Engineers Comments Regarding Surface Water Drainage

Application Reference:	AL/54/24/DOC	Reviewer Reference:	ADC/EXT2/D2134/100
Planning Officer:	David Easton	Date of Review:	08.06.2026
Site Name:	Nyton Nursery Nyton Road Westergate PO20 3UQ		
Application Description:	Approval of details reserved by condition imposed under reference AL/3/19/PL relating to conditions 18- as-built drawings of surface water drainage scheme, 19 - surface water drainage scheme, 20 - works to watercourses and 21 - maintenance and management of surface water drainage scheme.		
Assessment Number:	1 of 2

TYPICAL SECTION THROUGH ROAD 1 CHAINAGE 10m – 270m
Scale 1:15

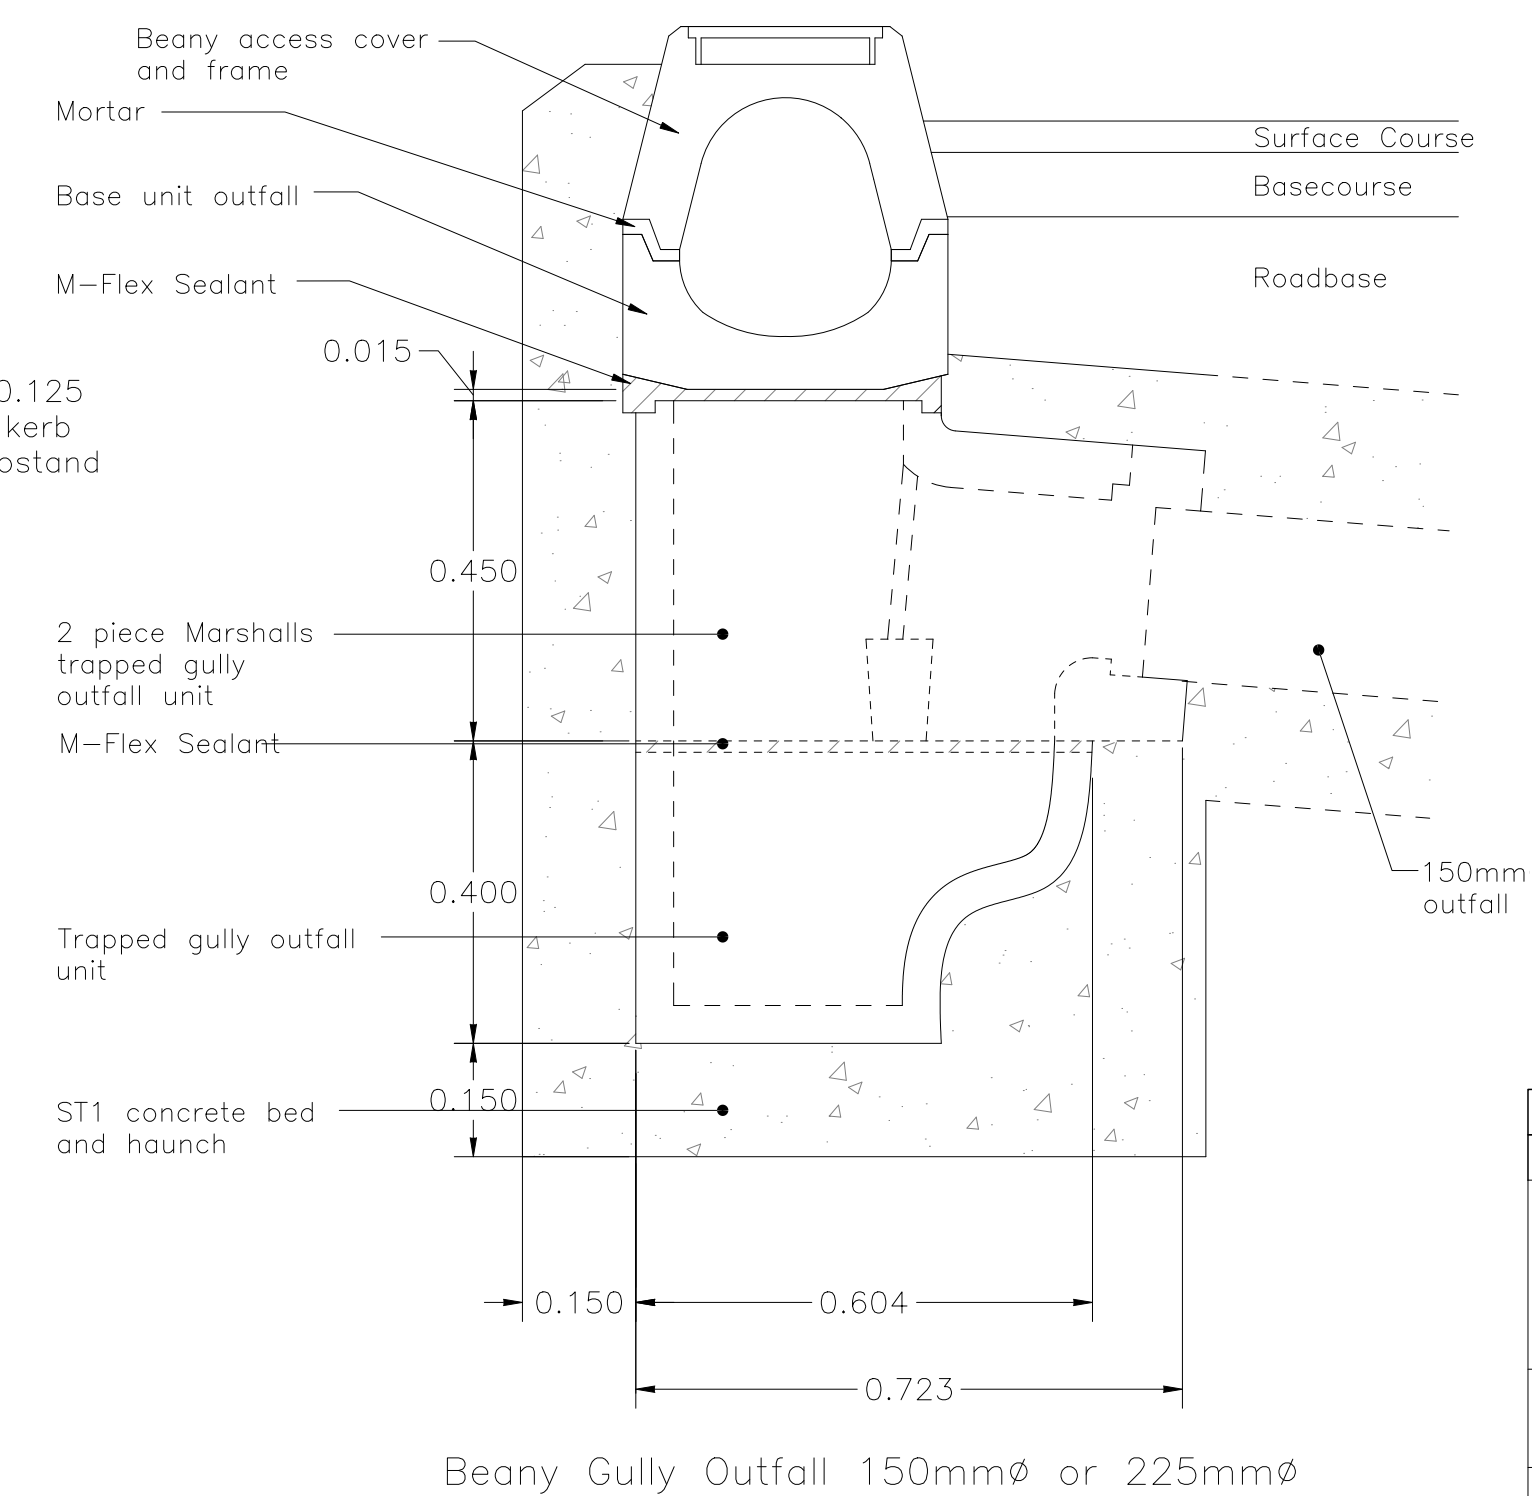
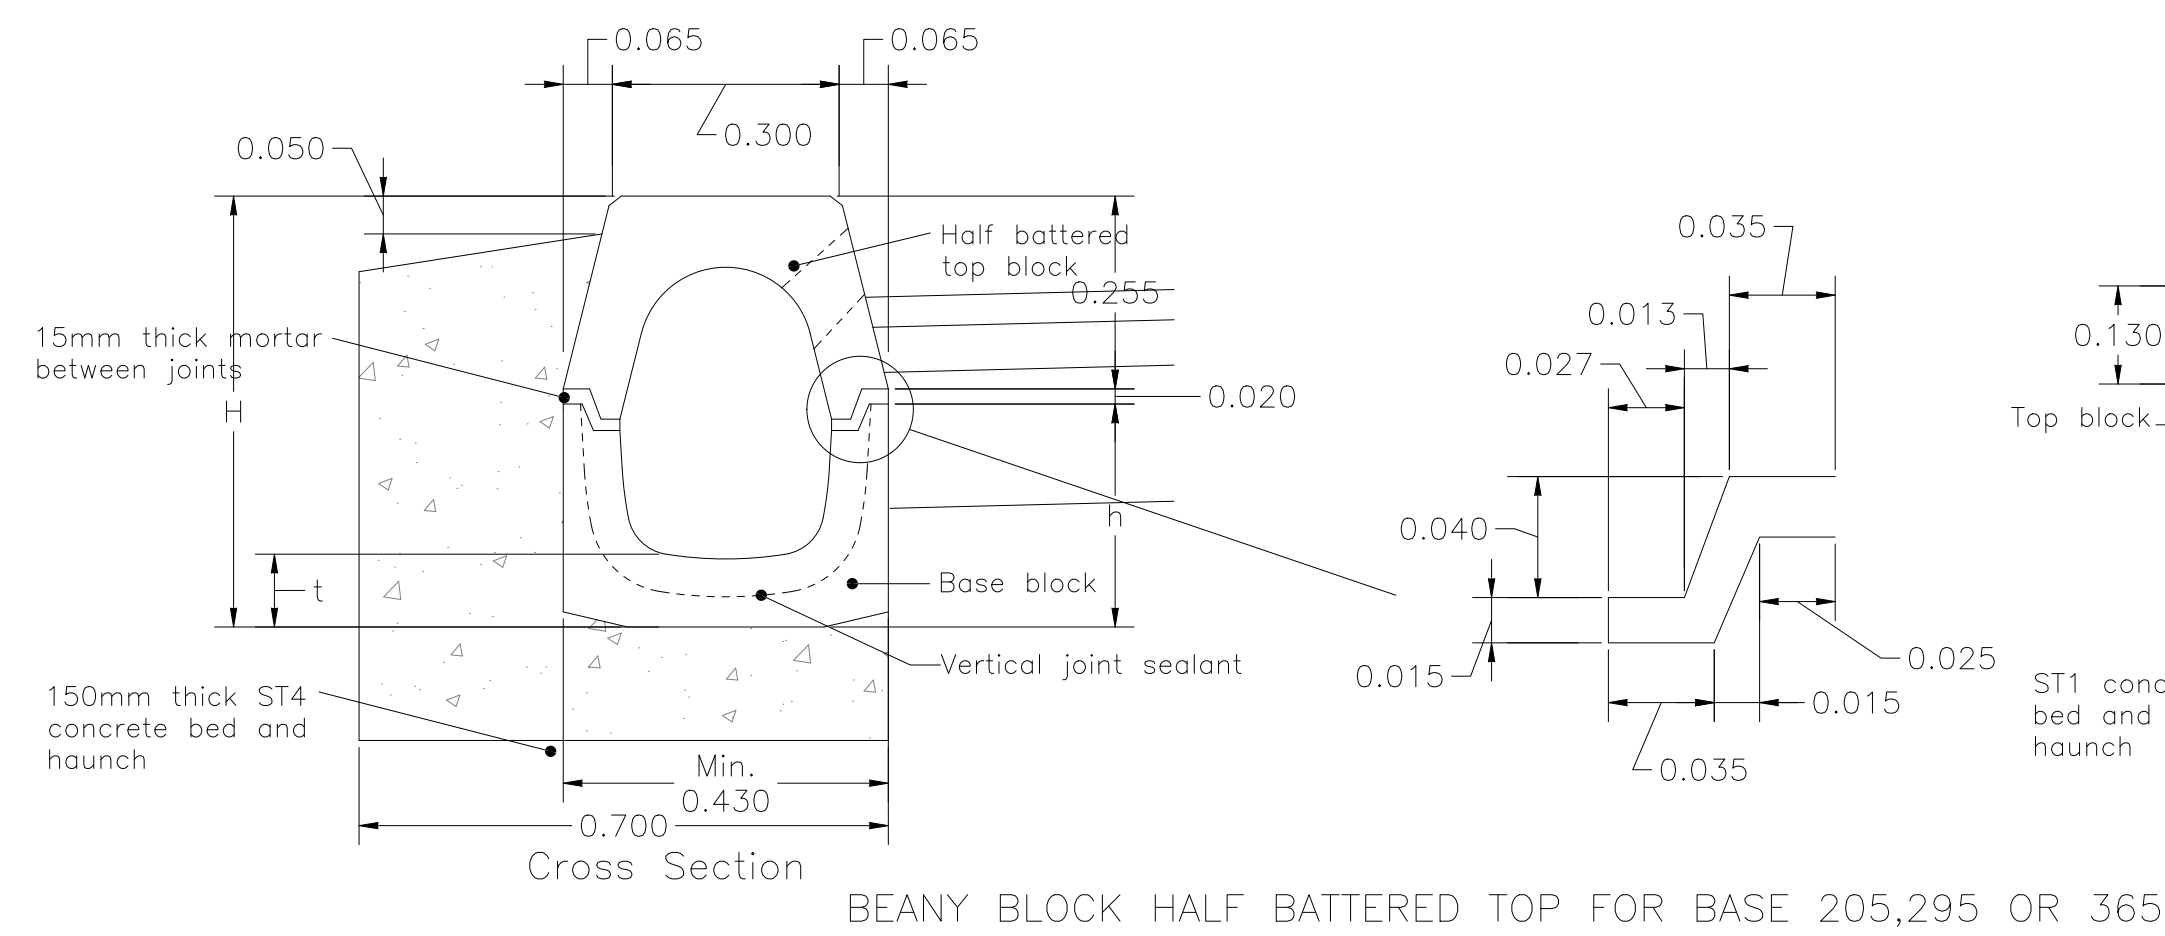
6.	ADC 28/04/2023: Please confirm how silt will be collected and removed where rainwater pipes are shown to connect directly to permeable paving sub base. Eg. Plot 122, 125, 126 etc. Designer response 14/12/2023: Silt will be collected via a trapped gully pot. See drawing '5655-22_A Sewer Details' ADC 21/02/2024: This needs to be discussed at detail in the management & maintenance report. Routine gully maintenance dictates gullies will be pressure cleaned which will result in some silt/debris being washed down into the sub-base where no control catchpits can be used to mitigate this. Eventually the sub-base will become clogged resulting in a significant loss of storage and conveyance. Sub-base replacement must be considered. Furthermore this does not comply with CIRIA treatment	Paragraph 4.19 of the SuDS M&M plan details sub-base replacement frequency. The EA have not been consulted. Roof water being discharge to formation level carries minimal contamination risk and the lowest mitigation indices. Gully socks will be added to road gullies.	Noted. Noted, please ensure gully socks, sponges or other equivalent products are installed. Comment closed.

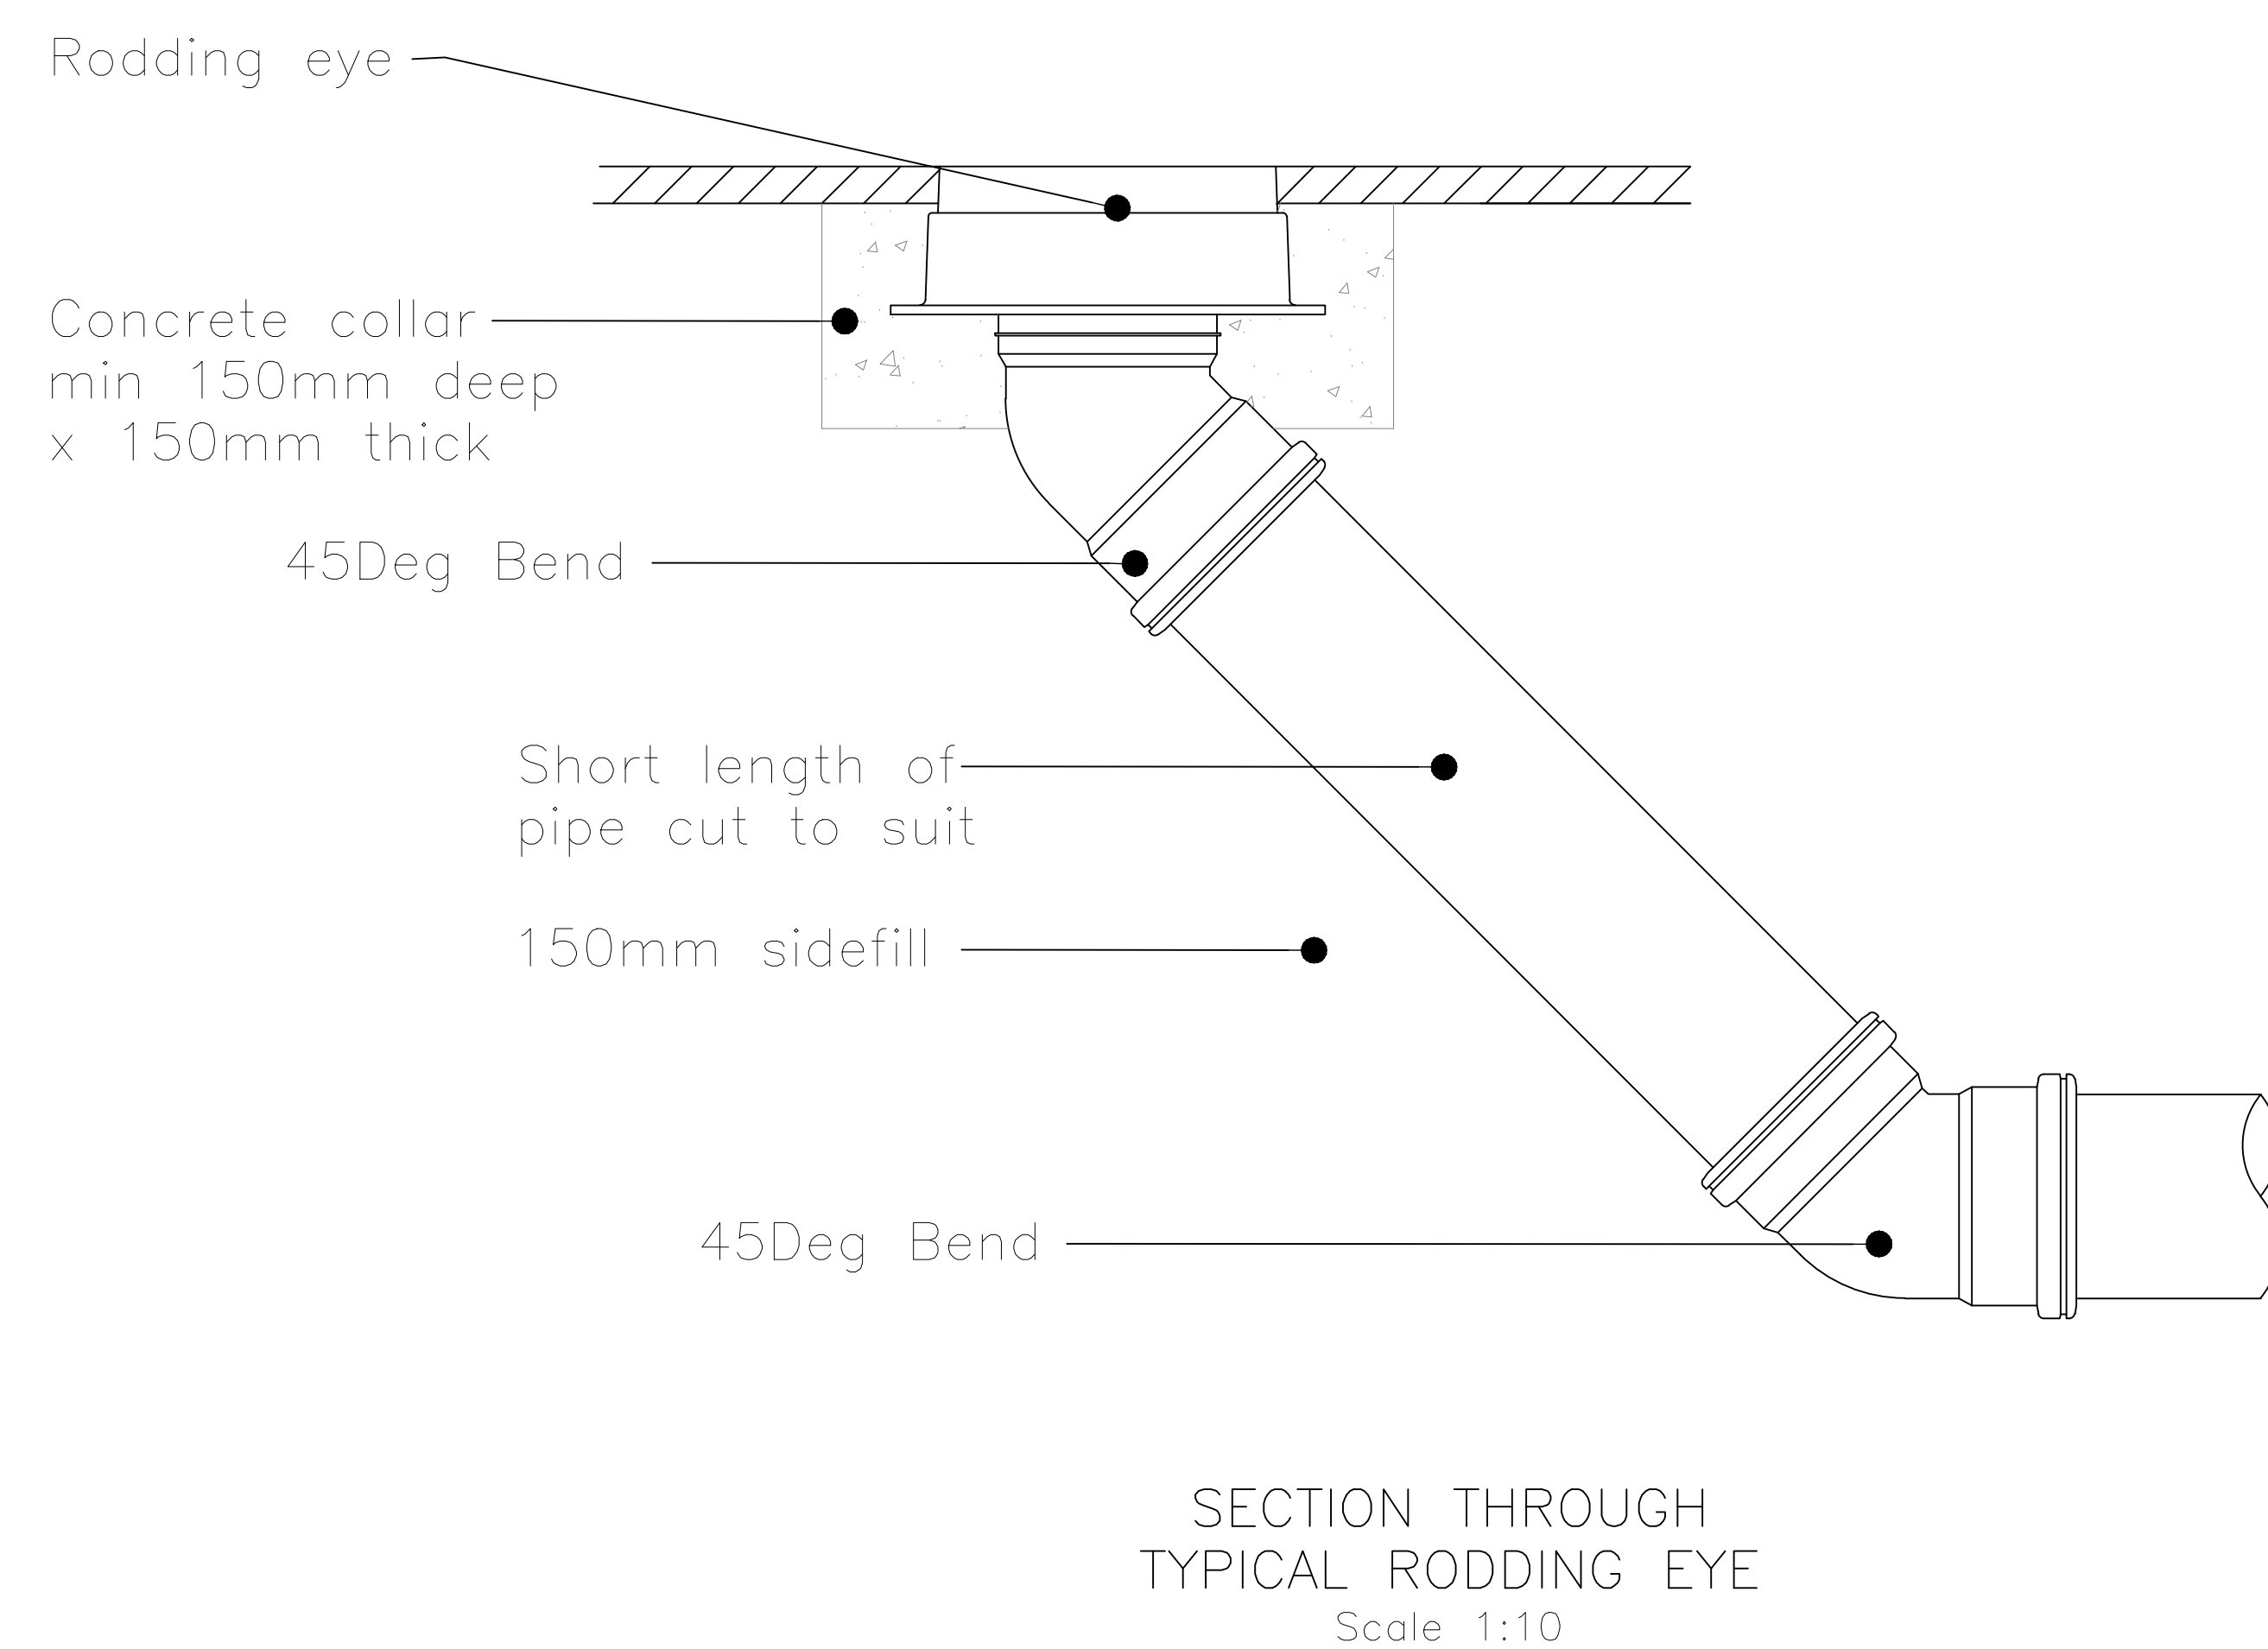
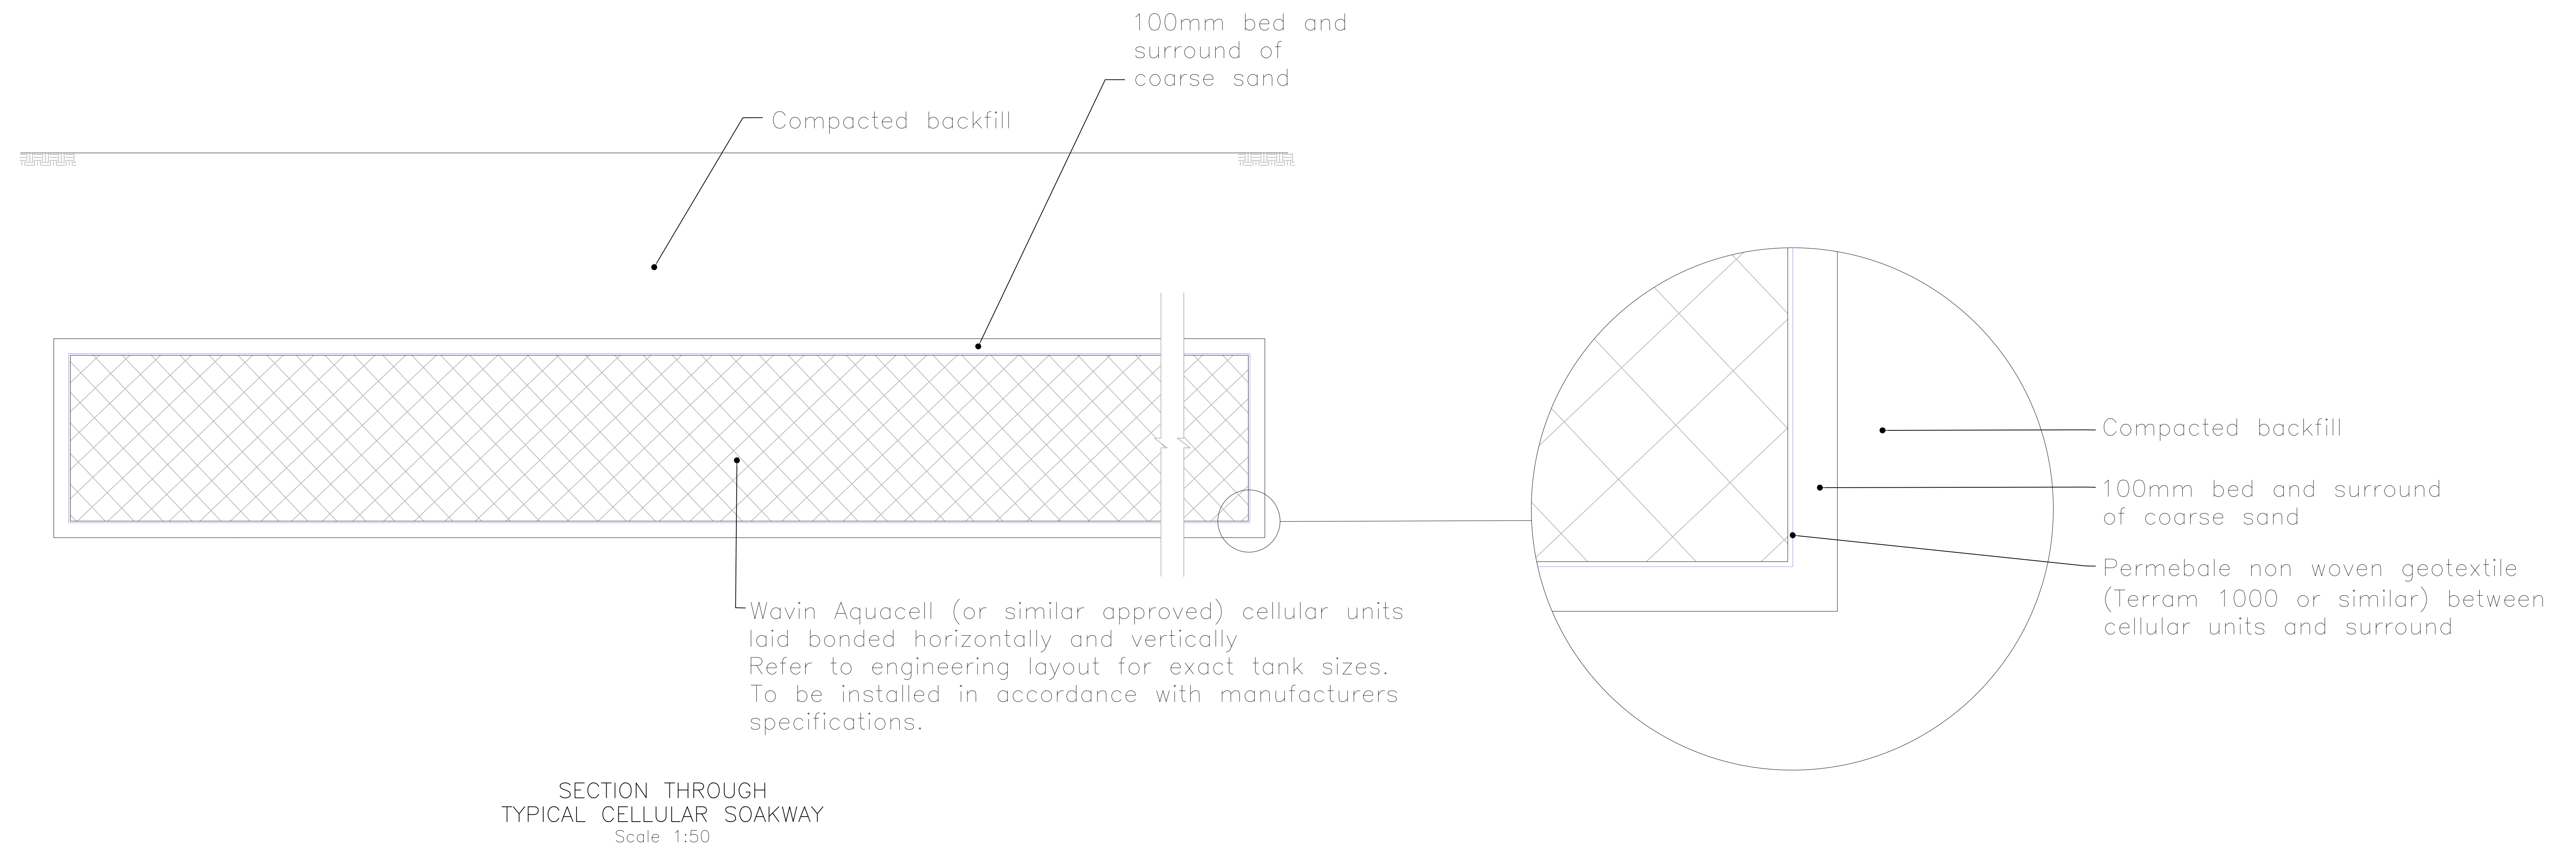
18.	ADC 28/04/2023: Please provide construction details for the proposed surface water drainage system including details for flow controls.	Please see construction details.	The swale make-ups are not advised in full? Some details show topsoil placed directly above granular material, others show parts of the gravel top may	The designer has not provide a response or further information to resolve this comment. Comment outstanding.	Refer to the following dwgs: *Flow controls - 5655:70_H *Catchpits - 5655:22_A *Permeable Pavement - 5655:20_R & 5655:22_A *Pipe bedding details - 5655:21_D *Soakaway & Rodding Eye - 5655:27

Designer response 14/12/2023: NA ADC 21/02/2024: Comment outstanding.		have other impervious fill sitting on top? Numerous other details for pipework, bedding, rodding points, catchpits, cellular soakaways, permeable pavement make-ups are missing.	Refer to dwgs: 5655:71_C for Swale 2 5655:81_A for Swale 1&3 5655:82_A for Swale 4&5 5655:83_A for Swale 6 This shows Swales 1,2,3 & 4 construction to be 150mm of grass seeded topsoil on existing ground. Swales 5 & 6 shown to be 150mm of grass seeded topsoil on existing ground with a stone trench below the base sections of the swale wrapped in a permeable membrane.
